A1 Birtley to Coal House Development Consent Order

Written questions – responses

Figure 1 - Environmental Constraints Map

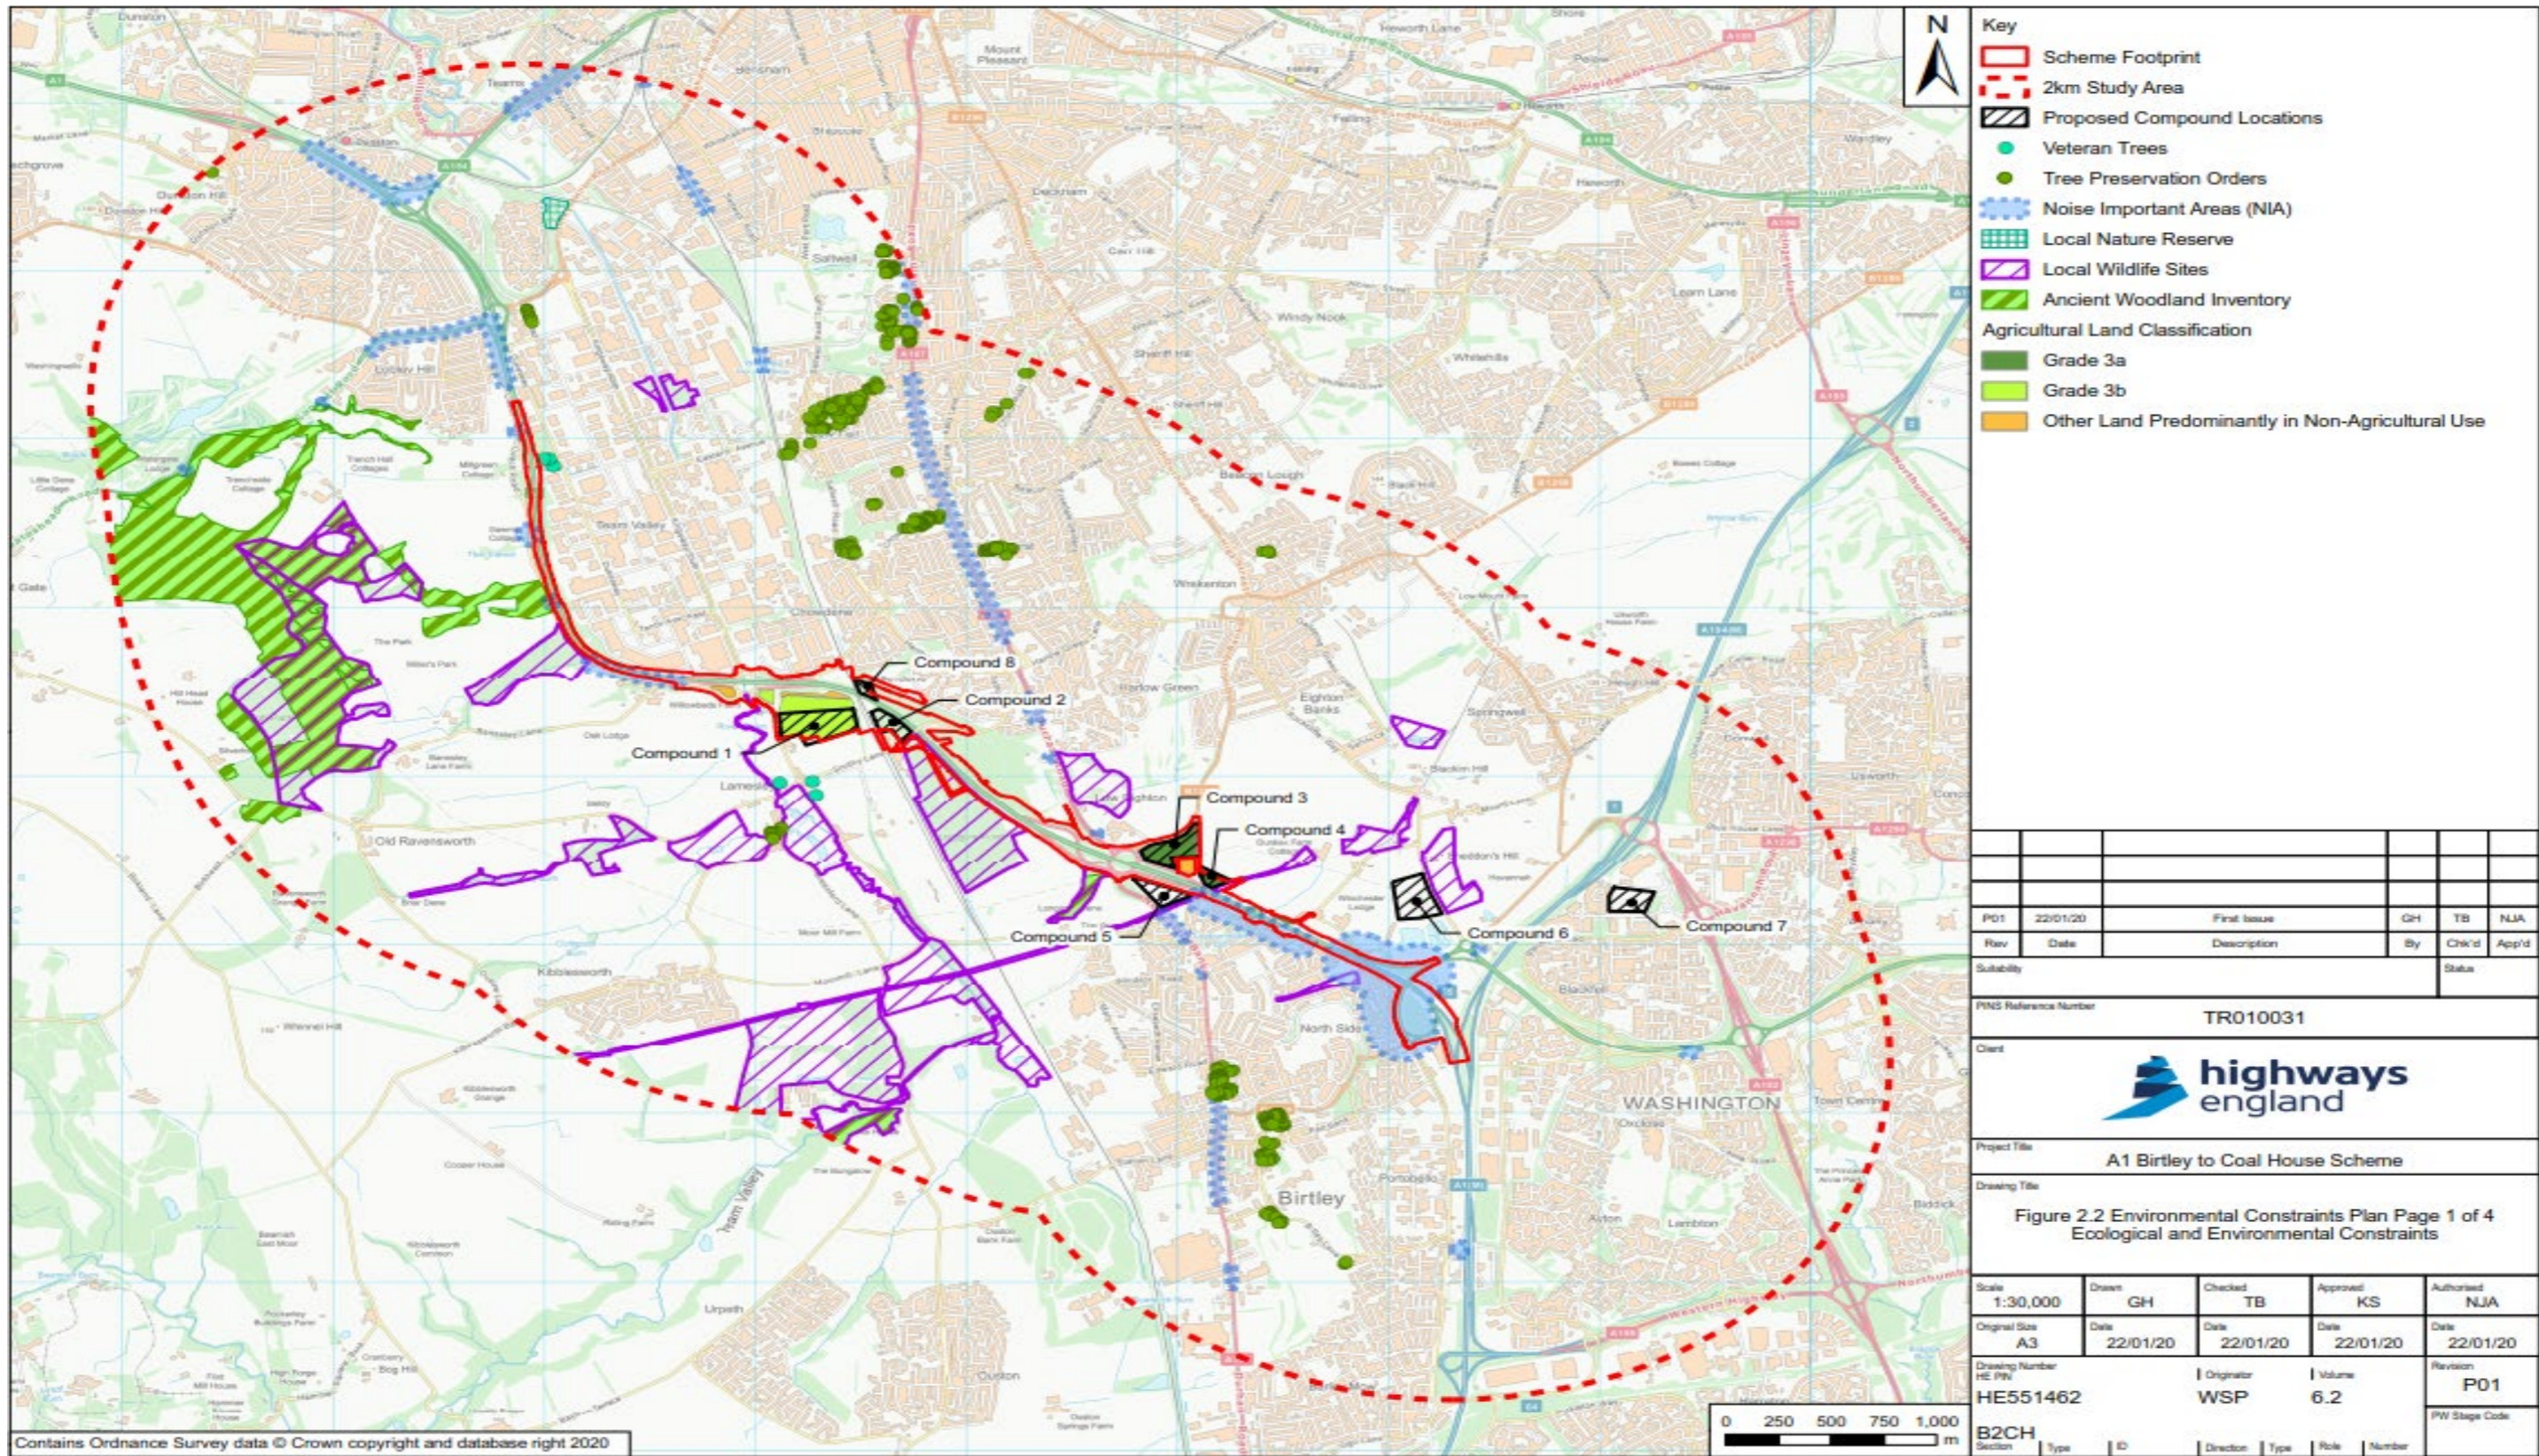
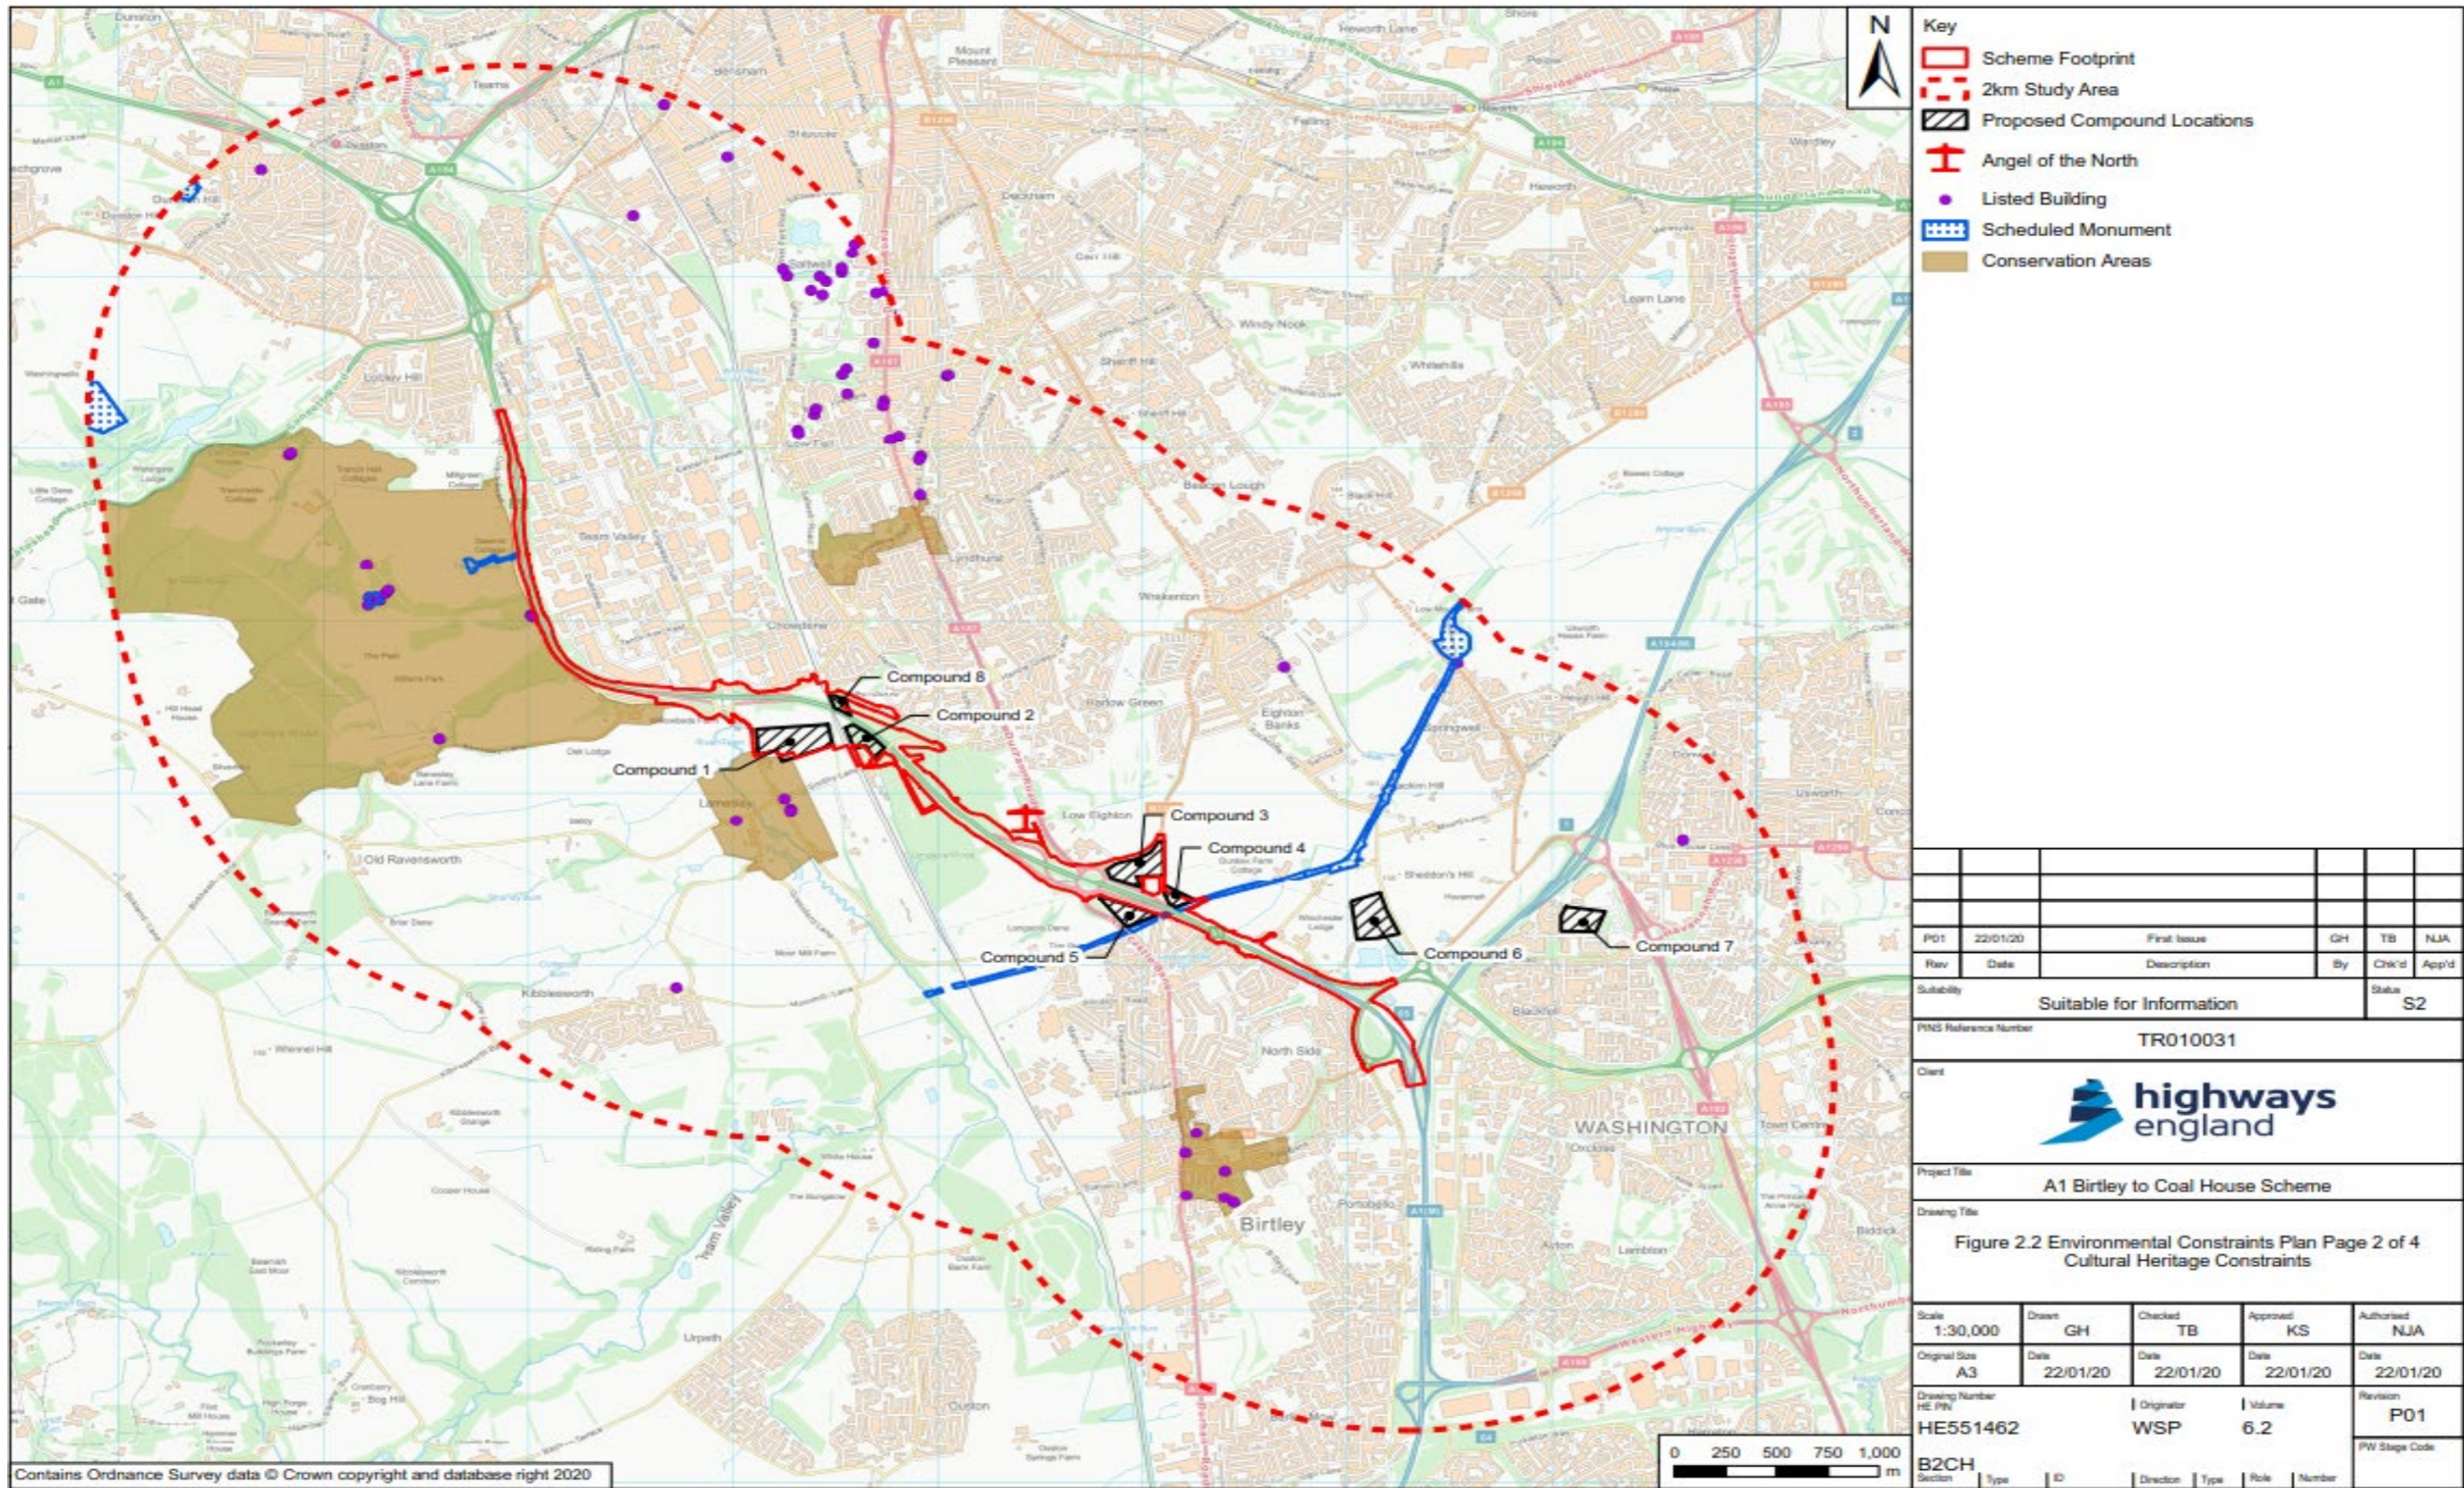
Appendix A shows the proposed location and layout of the site compounds to be used during the scheme. Details of the access arrangements for these, and related arrangements for wheel washing and road sweeping, should be agreed with Gateshead Council prior to their construction.
